# CITY OF ALBUQUERQUE

July 27, 2012

RE: Los Angeles Center (Lowe's out-parcels), Tracts A-1-B-1-B & A-1-B-1-C  
**Grading and Drainage Plan for Grading, Paving and Building Permit**  
SW Corner of Paseo del Norte & San Pedro PE Stamp: 7/11/12 ( **D18-D014D** )

ENGINEER'S SEAL	LOS ANGELES CENTER	DRAWN BY WCU
MASTER UTILITY PLAN	DATE 3-28-12	
PLAN	21204-LAYOUT-3-28-12	SHEET #
DAVID SOULE P.E. #14522	<i>Pio Grande Engineering</i> 1006 CENTRAL AVENUE SUITE 201 ALBUQUERQUE, NM 87106 (505) 872-0999	JOB # 21204

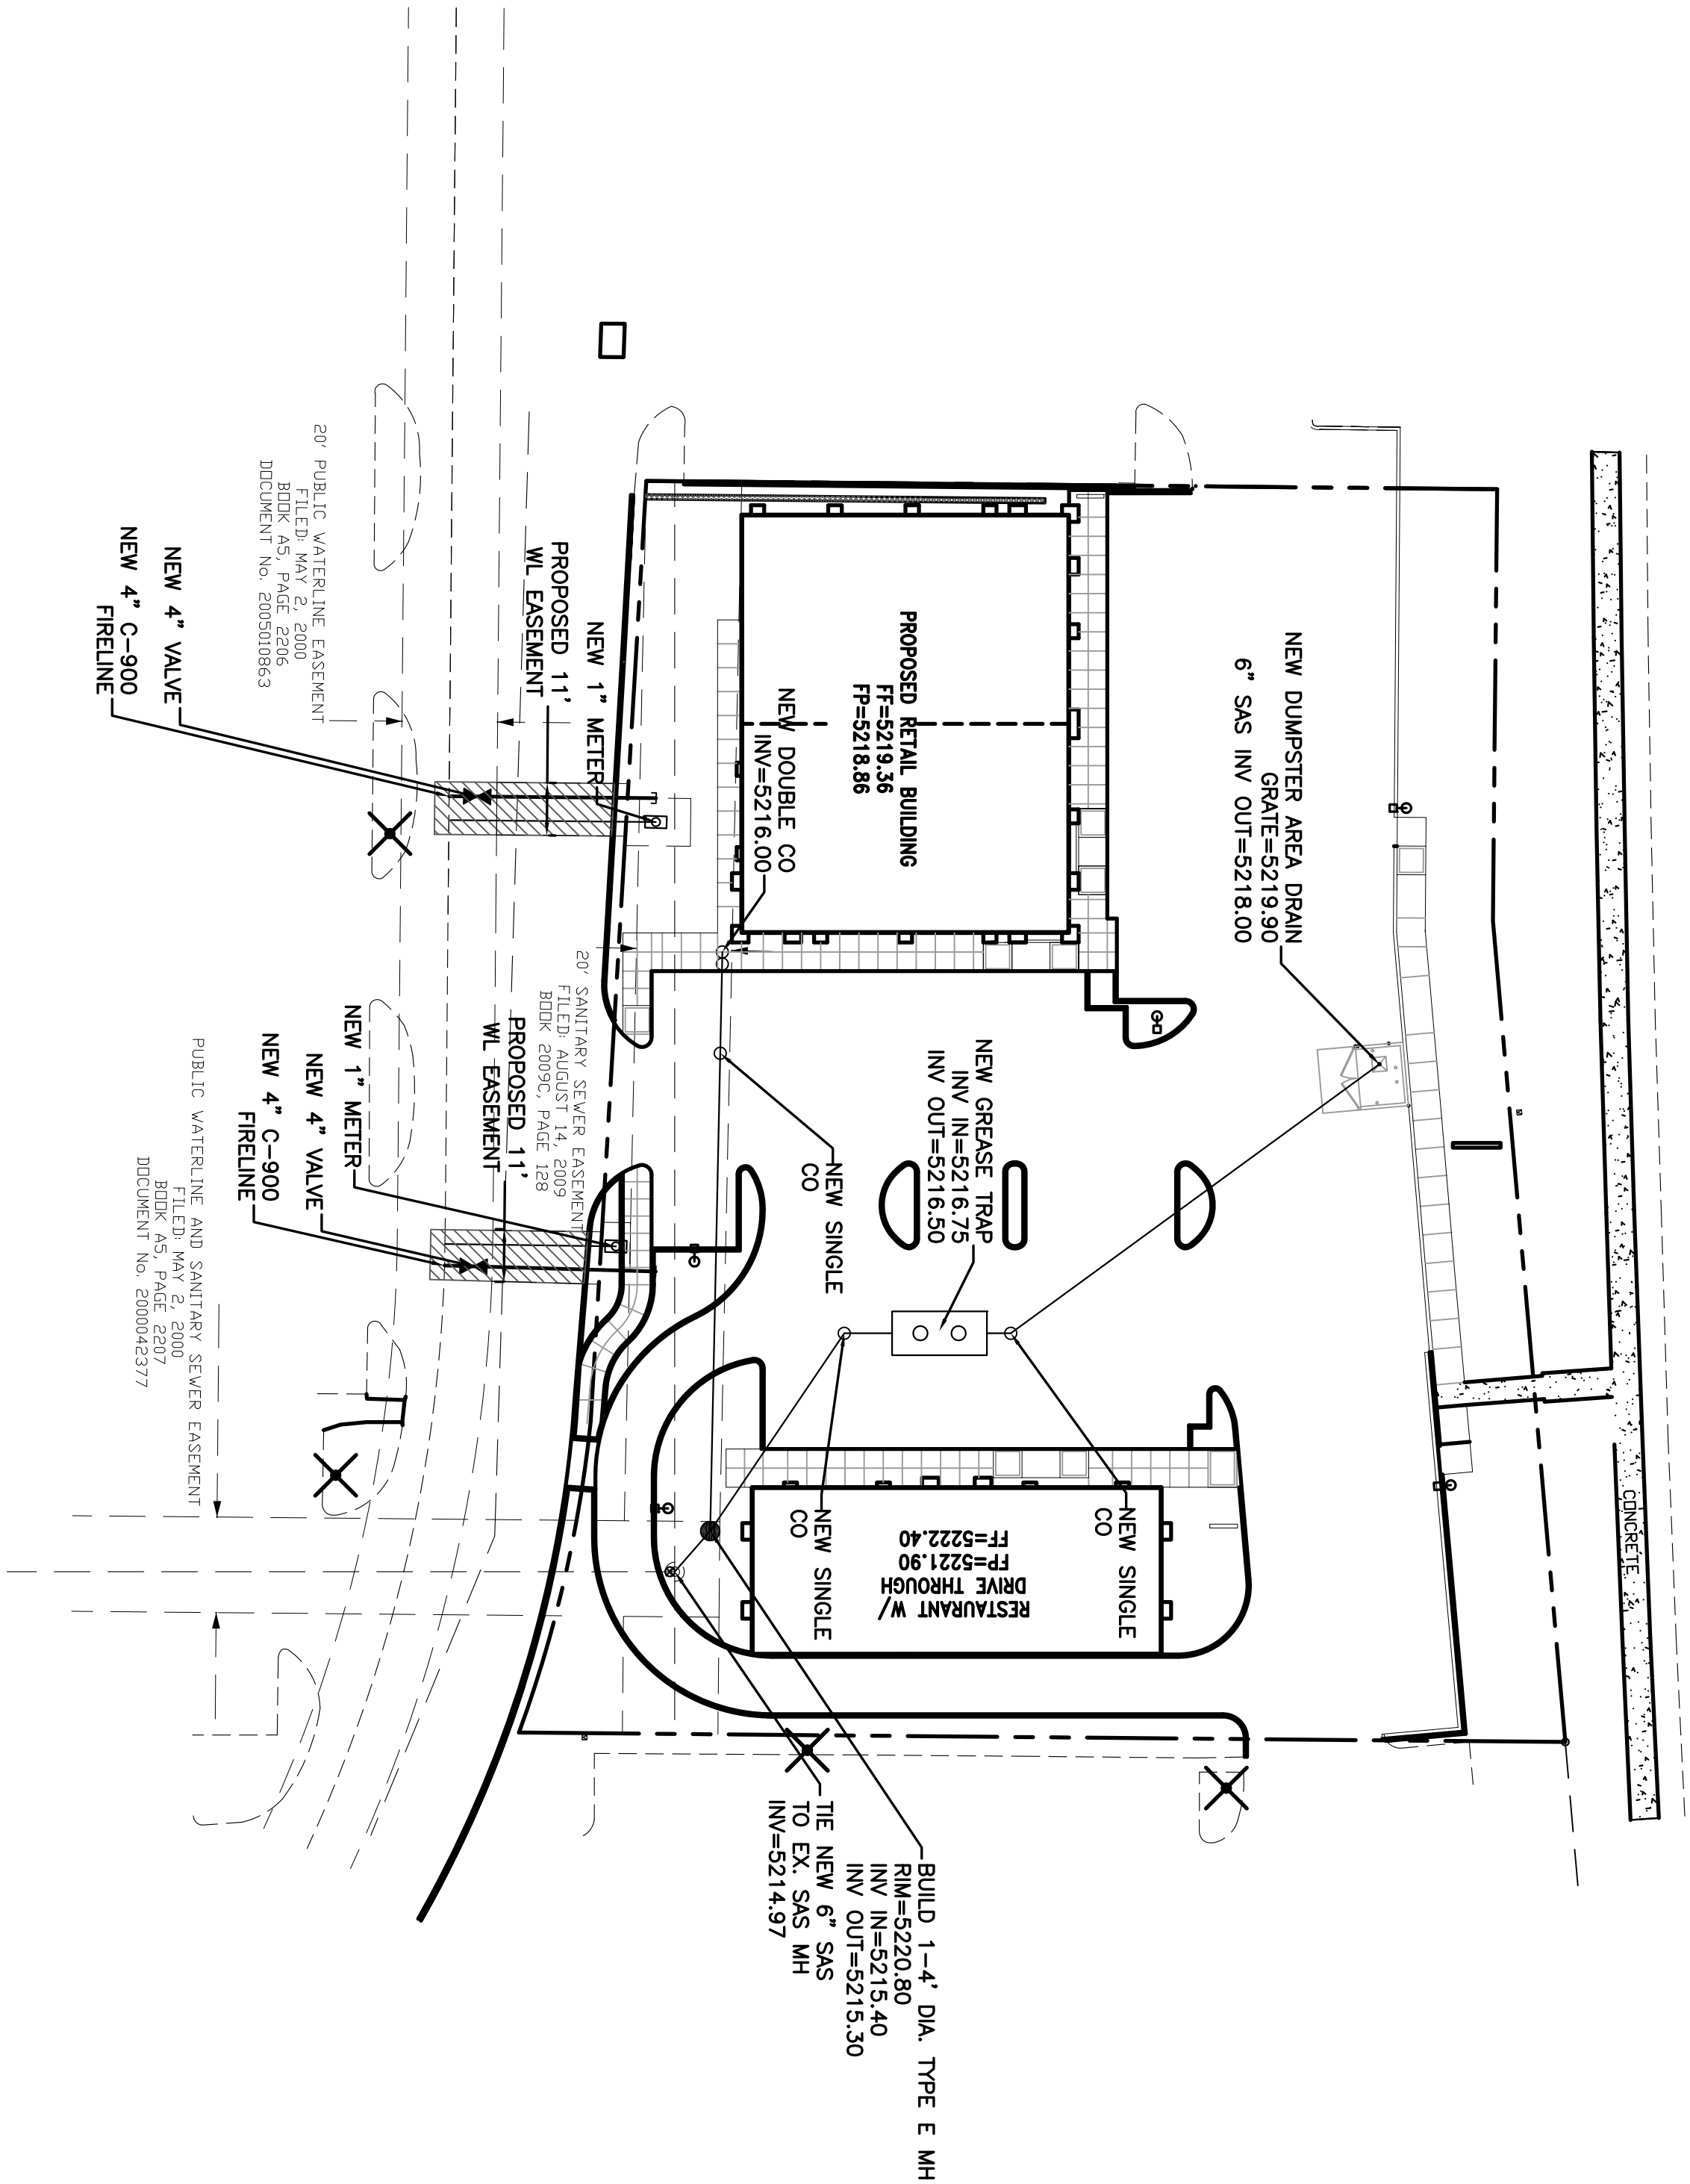
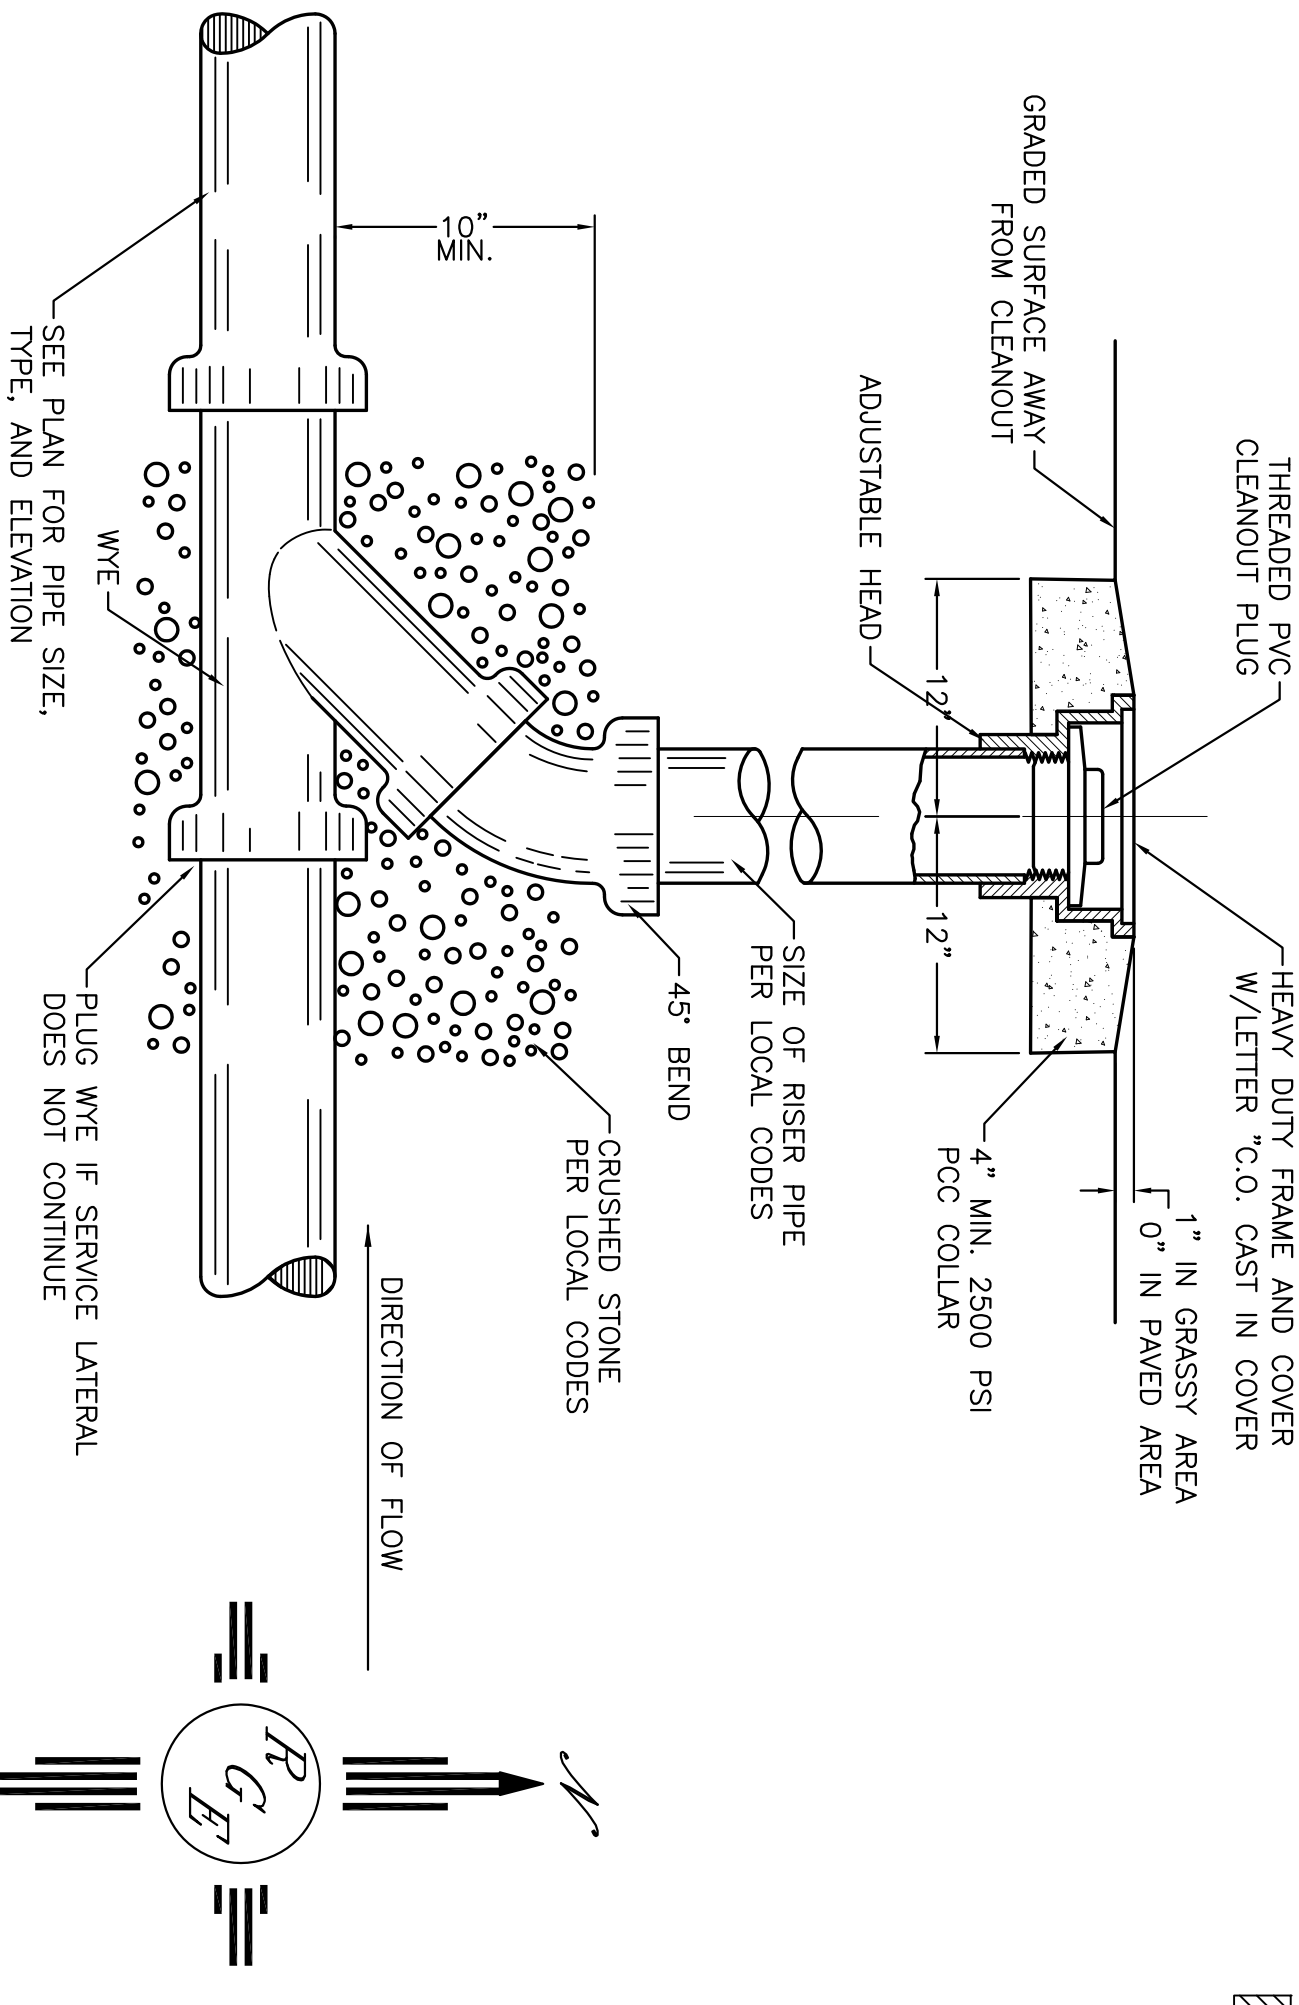
1. Per the DPM Chapter 22 Section 9, runoff from the trash enclosure pad is required to drain to the sanitary sewer.
2. The Building Permit set must include the revised Master Utility Layout, which shows the Dumpster Drain routed through a grease trap, with and approved discharge to the Sanitary Sewer system.
3. Albuquerque's MS4 Permit became effective March 1st, 2012. Grading and Drainage Plans and Drainage Reports must comply with the requirements of the new permit (<http://www.cabq.gov/planning/landcoord/Hydrology.html>).
